Request for Architectural Approval

New home build on Lot 7 ST ANDREWS. DR.

PROJECT NAME: FREES RESIDENCE

OVERALL SITE PLAN

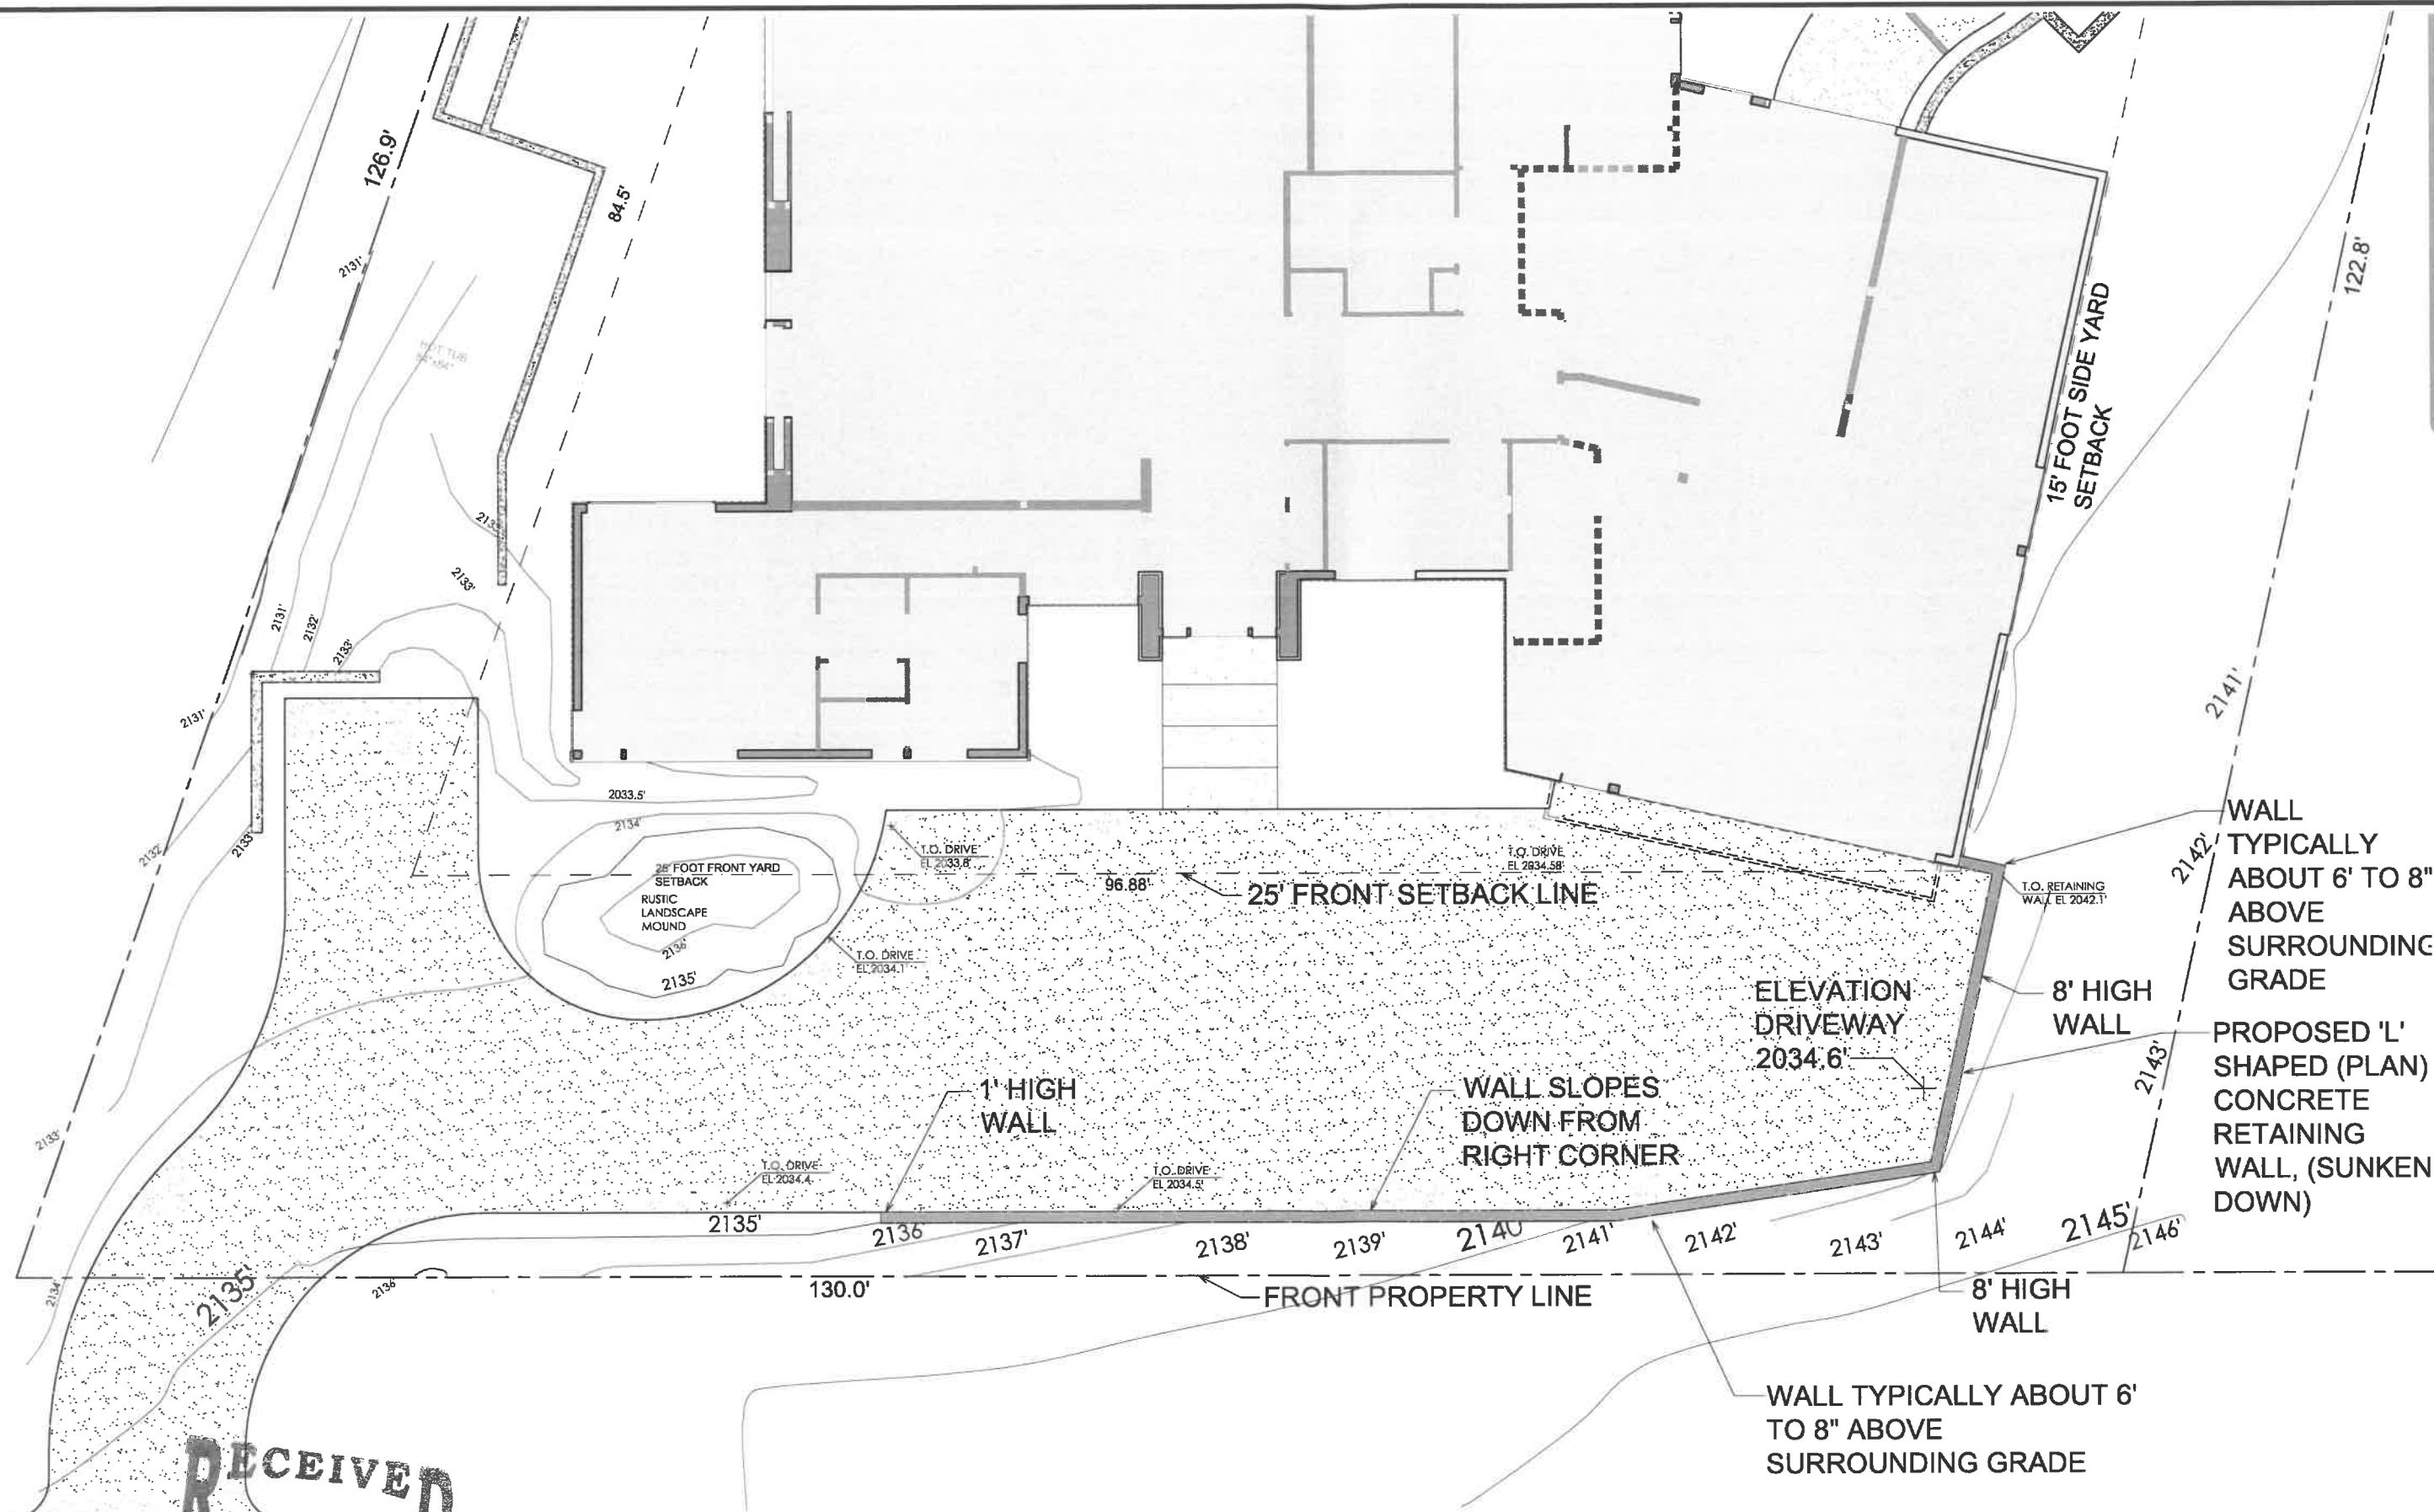
The home is a large home and will be fairly dominate on the lot. My only request is that they should make sure to locate the survey pins at the back of the building envelope where it borders the golf course. Cruse and Associates in Ellensburg can locate the pins if needed since they did the survey. Since this home is 15" off of the back building envelope line, we want to make sure there are no issues with encroachment. I don't see too many issues with errant golf balls in this location however there will be the stray golf ball. We are trying to not have nets along the course and since this is being built close to the back part of the lot we just want to make sure the Frees have every advantage of the view with out being hit by balls.

I believe I understand the way the house sits on the lot. I was at first concerned that it would block some of the view of Floyd Walkers home on lot number 8. It appears that it is positioned to so that Walker view will not be impeded. I have not double checked the heights however. You may want to confirm that. It looks like the home is nestled down where everyone should be happy.
